State Significant Development Application – SSD 9472

Proposed Sikh Grammar School – 151-161 Tallawong Road, Rouse Hill (Lots 42 & 43 DP 30186)

Table 1: Response Matrix

PMDL
 ARCHITECTURE
 INTERIORS
 MASTERPLANNING

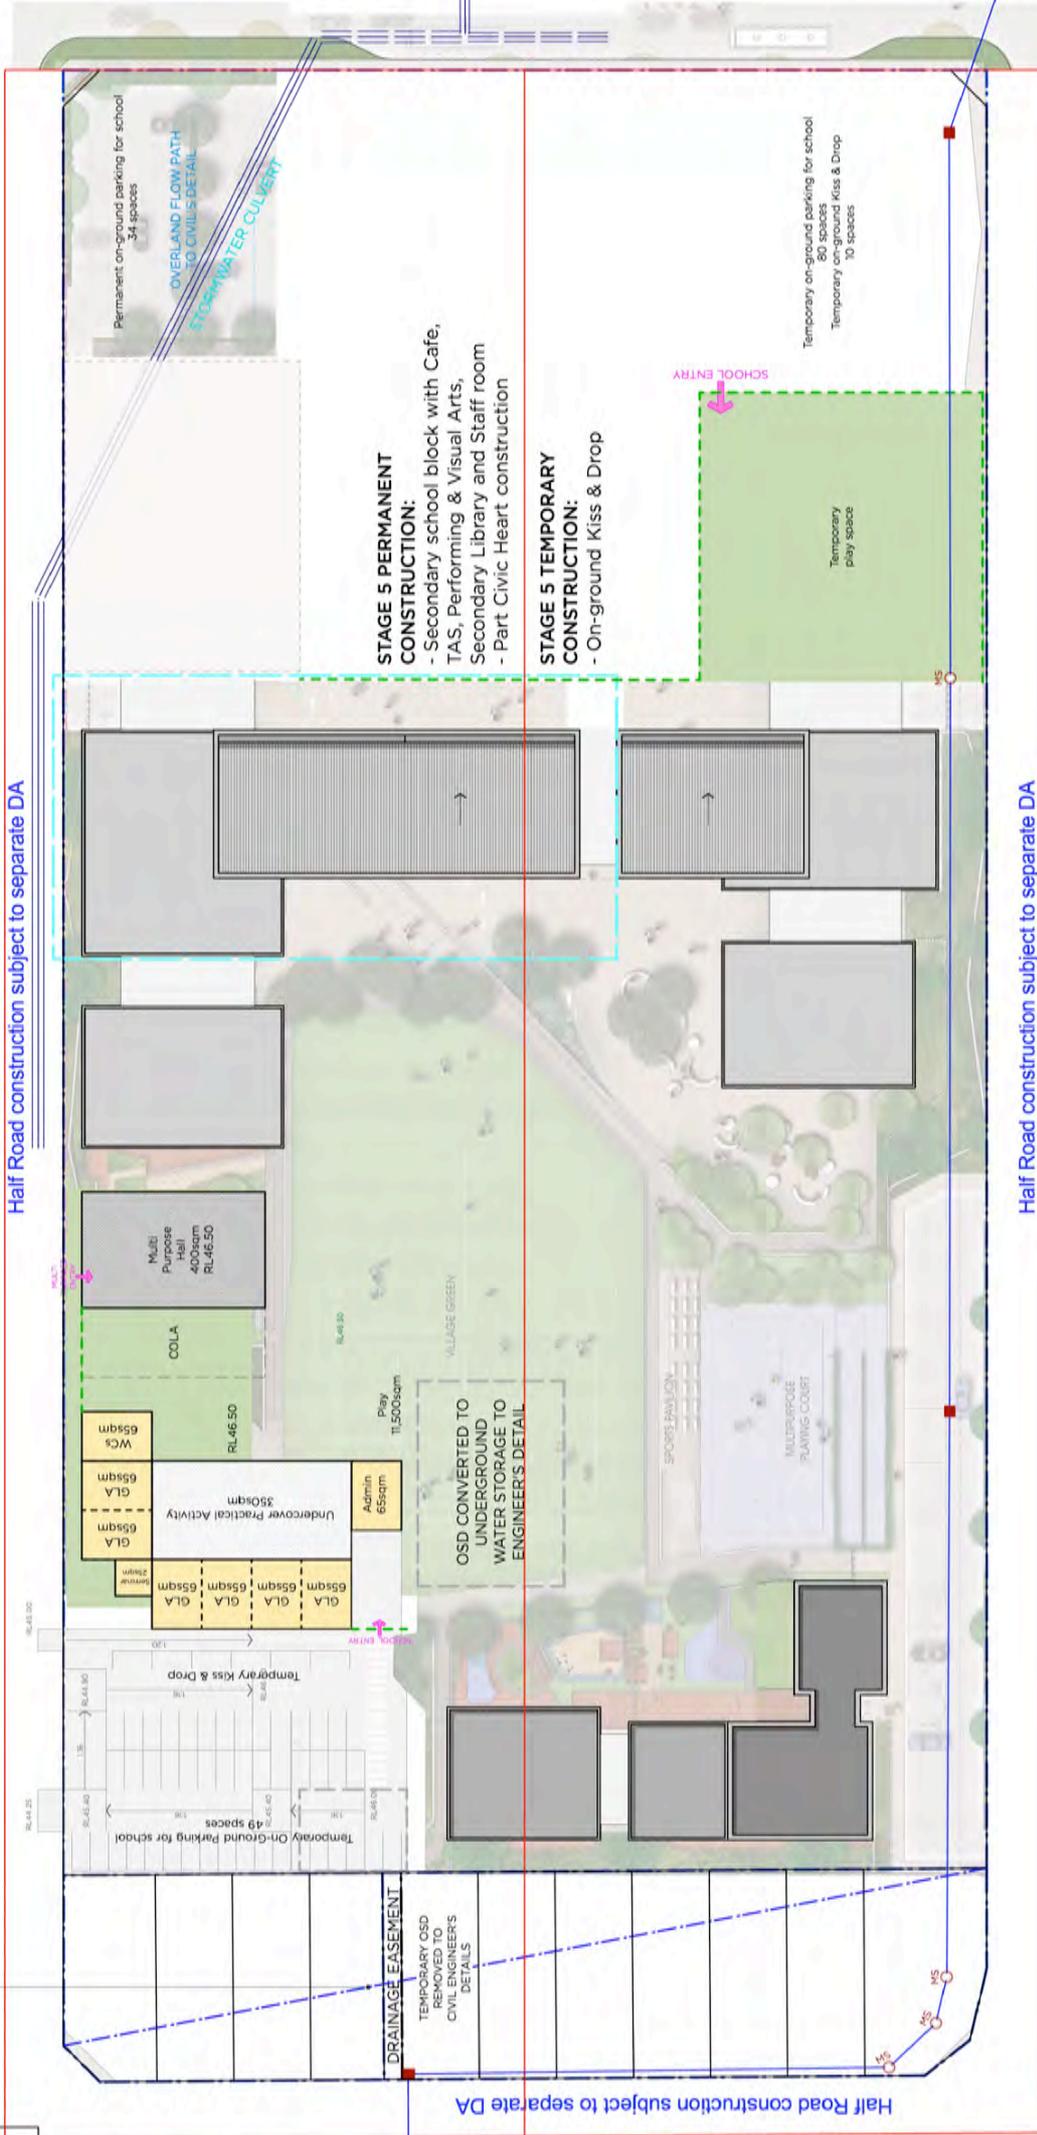
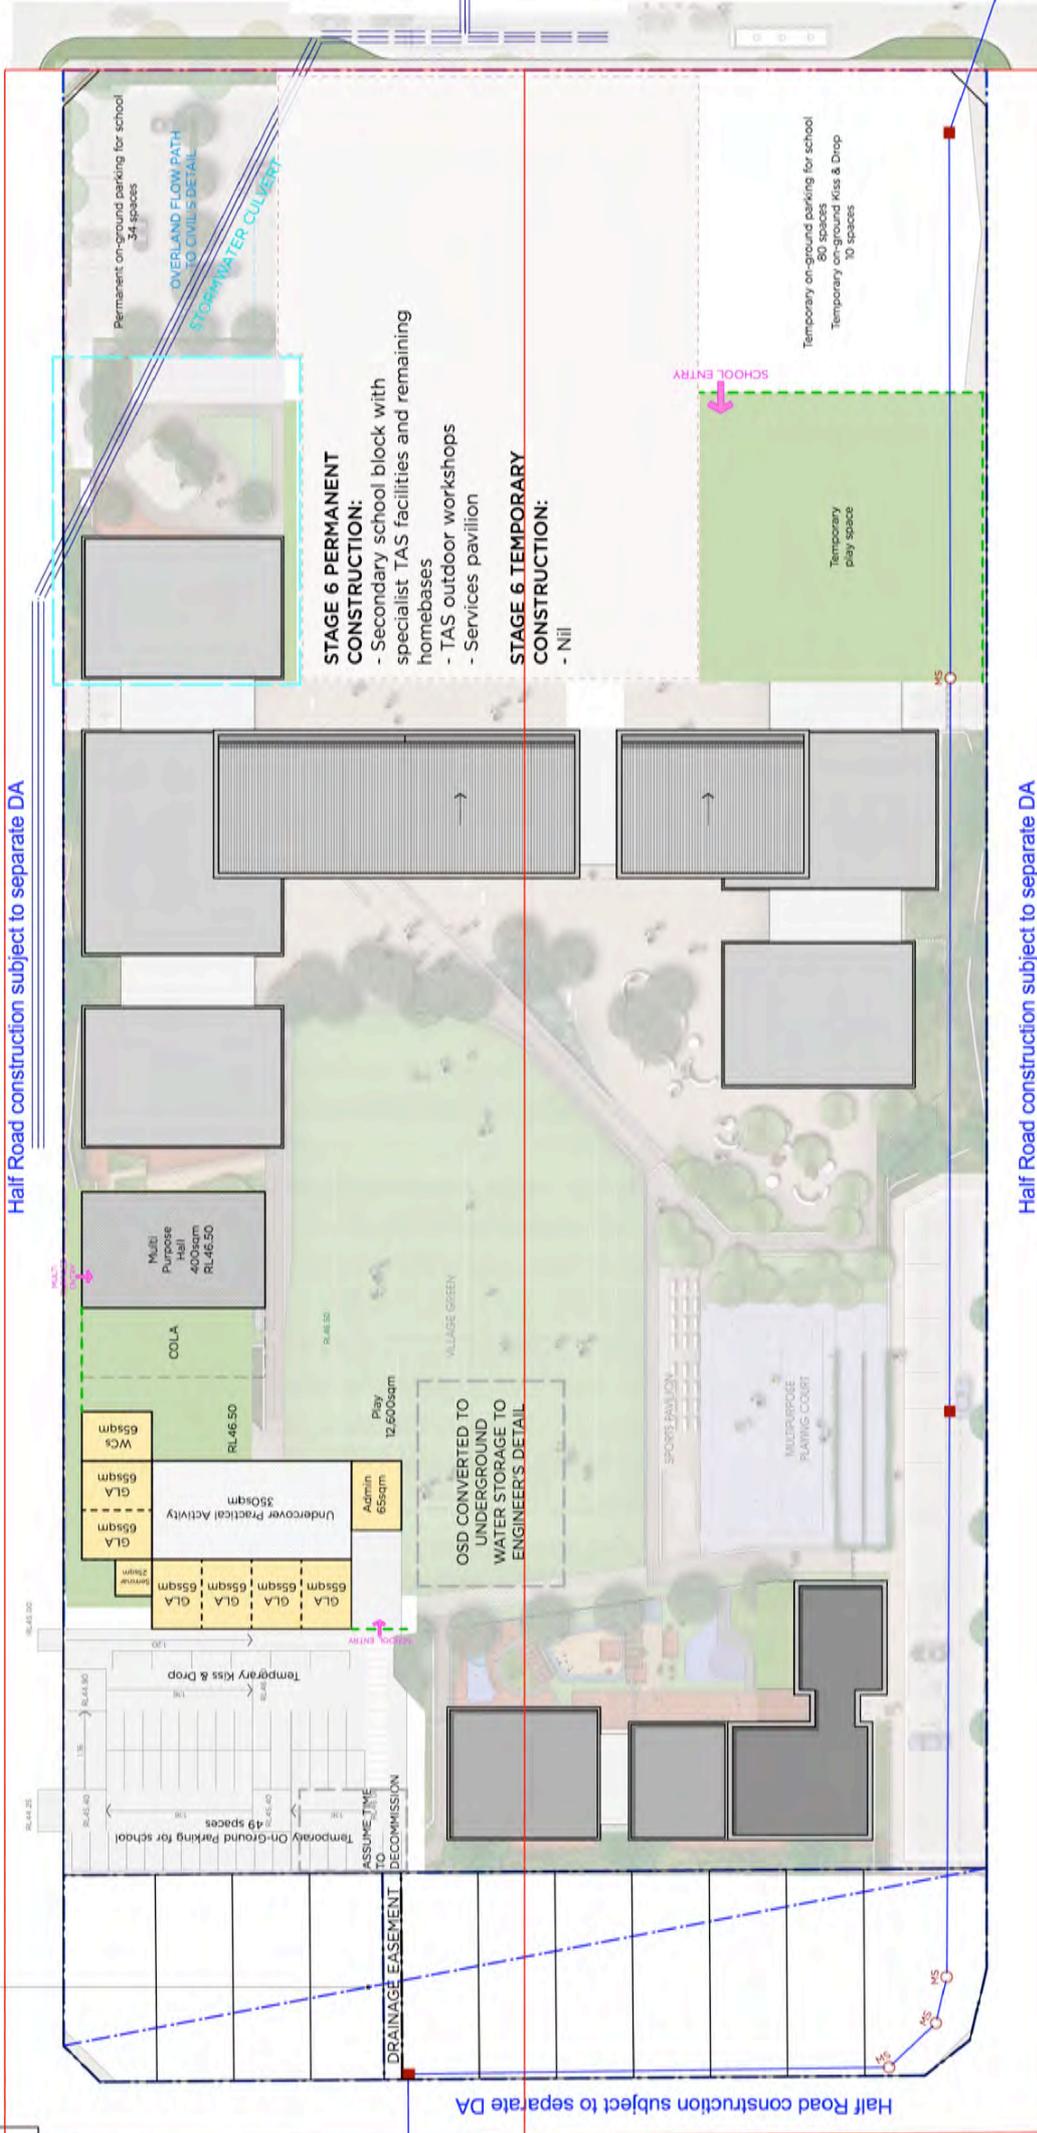
<p><i>The construction staging plan is to be amended to include timeframes of the duration of each of the construction stages (i.e. Jan 2021-Jan 2022).</i></p>	<p>pertaining to each construction stage of the Proposal (refer to Appendix 4). It is noted, that construction stage timeframes may vary depending on relevant Construction Certificates being obtained based on the requirement and demand for each component of the School and associated buildings / particulars.</p>
<p><i>Details are to be provided of the arrangements to be put in place during the staged operation of the site whilst construction is ongoing to ensure the safety of students, staff, other visitors and the public. Details are to include:</i></p> <ul style="list-style-type: none"> ▪ <i>timeframes of staging.</i> ▪ <i>safety arrangements, including how operational areas would be separated from areas of ongoing construction.</i> ▪ <i>access arrangements, including how school access areas would be safety separated from construction access.</i> ▪ <i>how the staging relates to the anticipated provision of local infrastructure, particularly the construction of full road carriageways surrounding the site.</i> 	<p>The Architectural Plans and Operational Plan of Management have been amended to consider and satisfactorily address the adjoining item pertaining to details of arrangements and protocols to be implemented during the staged construction and concurrent operation with respect to the Proposal's varied stages (refer to Appendix 2, 4 & 5).</p>
